From: [REDACTED]
To: [Hinckley SRFI](#)
Subject: Response to HNRFI additional information
Date: 04 February 2025 10:45:47

A summary of my feedback regarding the B4669 Hinckley Road/Leicester Road Sapcote issues is as follows:

A summary of my feedback regarding the proposed changes in the centre of Sapcote, surrounding the Co-Op is as follows:

Drawing Title
SAPCOTE VEHICLE TRACKING SHEET 1

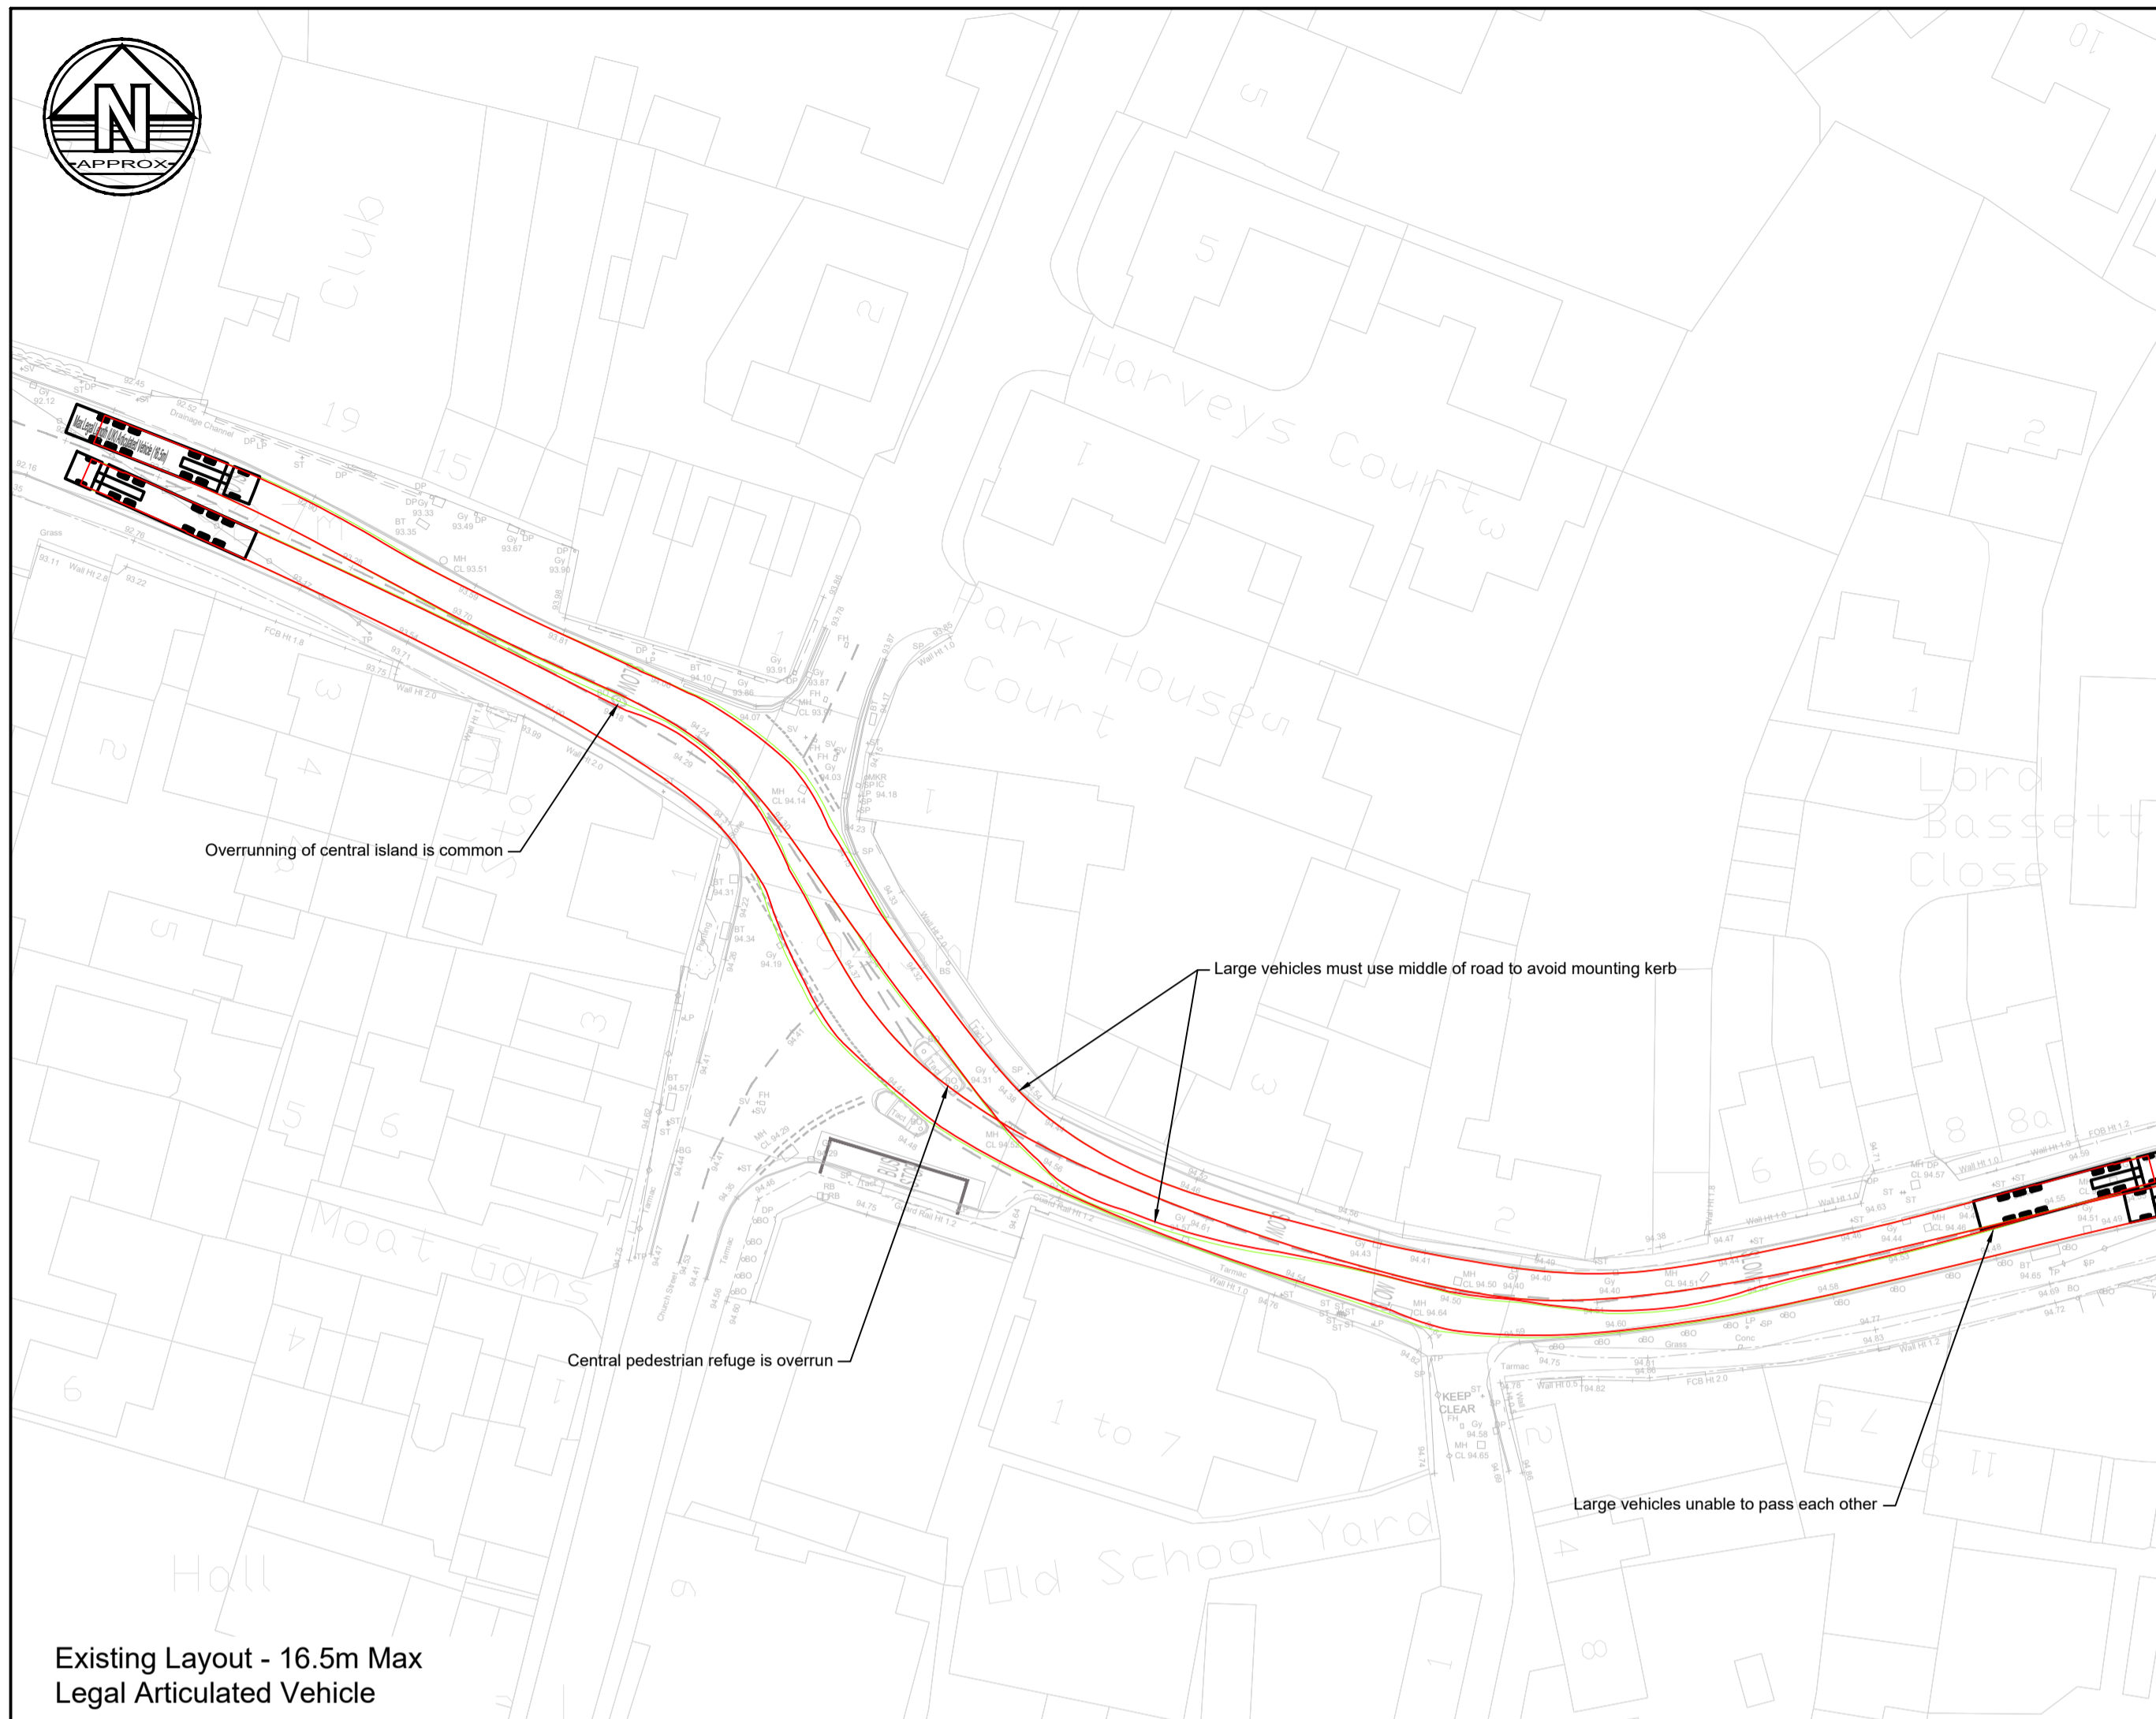
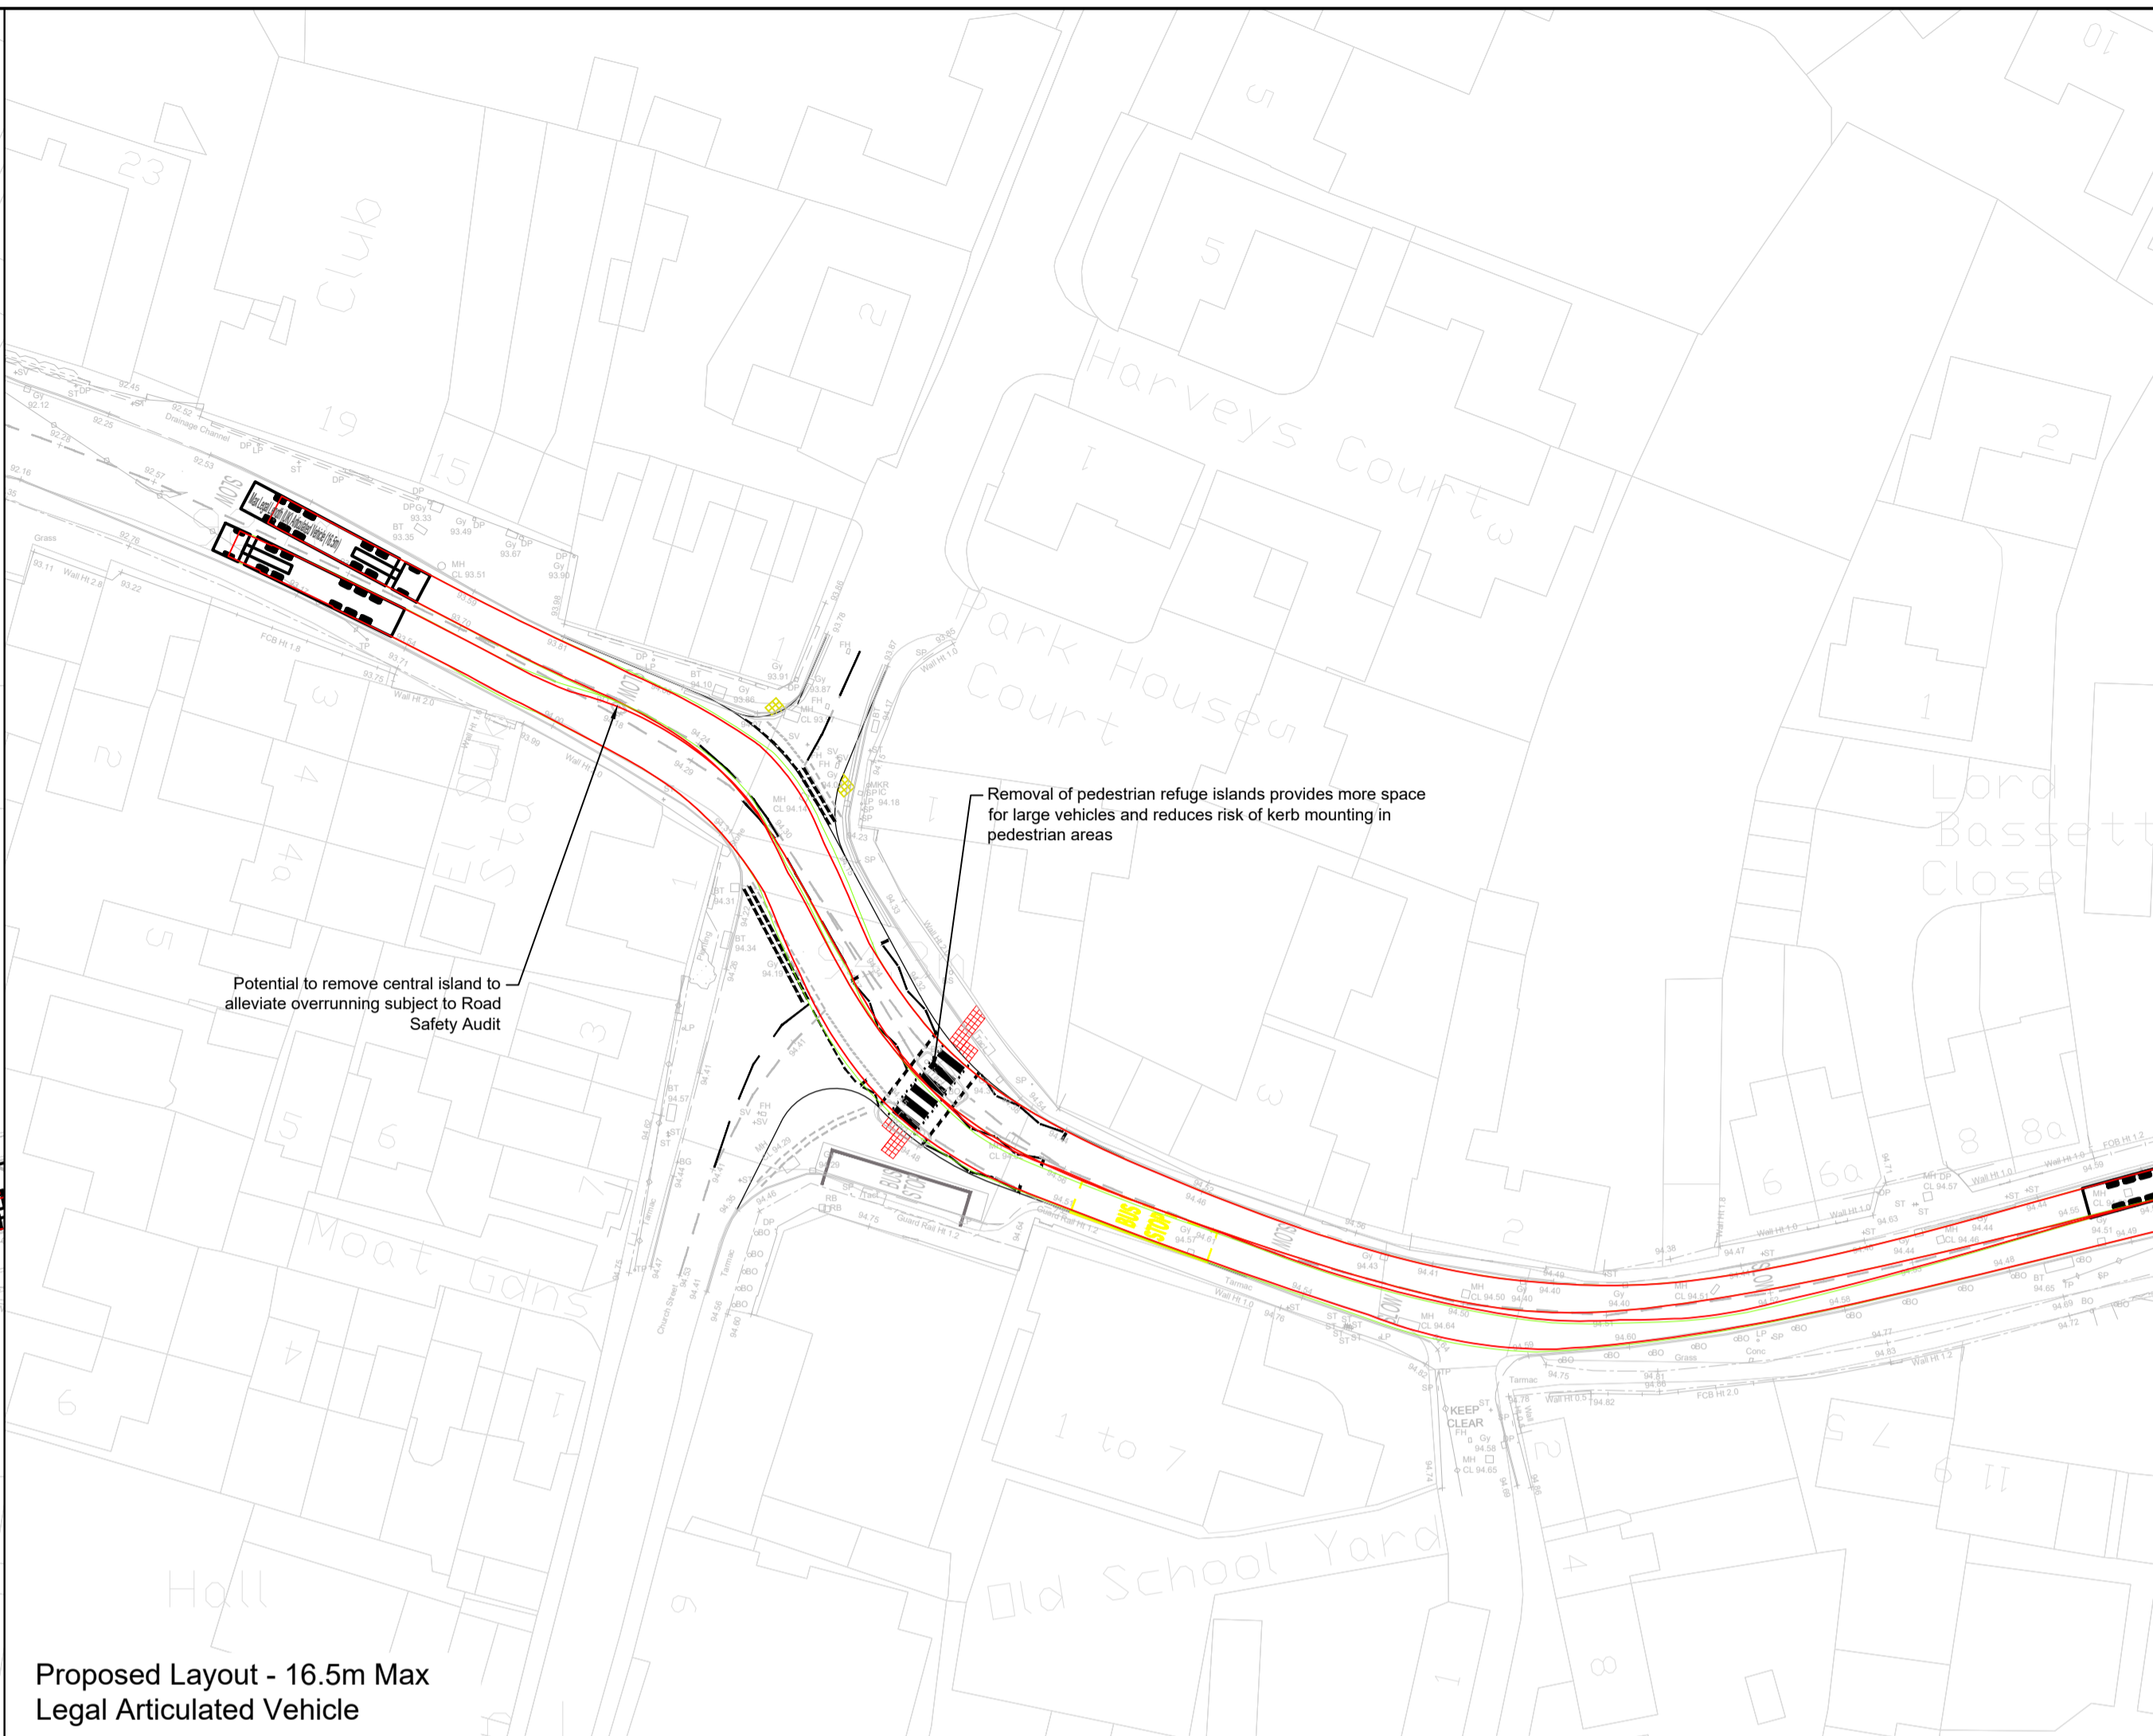
- Narrowing the Hinckley Road/Leicester Road to restrict the number of Lorries coming through Sapcote is poorly thought out. There is no provision for what happens when there are two oncoming vehicles in the narrow part of the road, or for which direction has priority. There is no room for vehicles to wait and this will force a vehicle onto the pavement to avoid a collision.
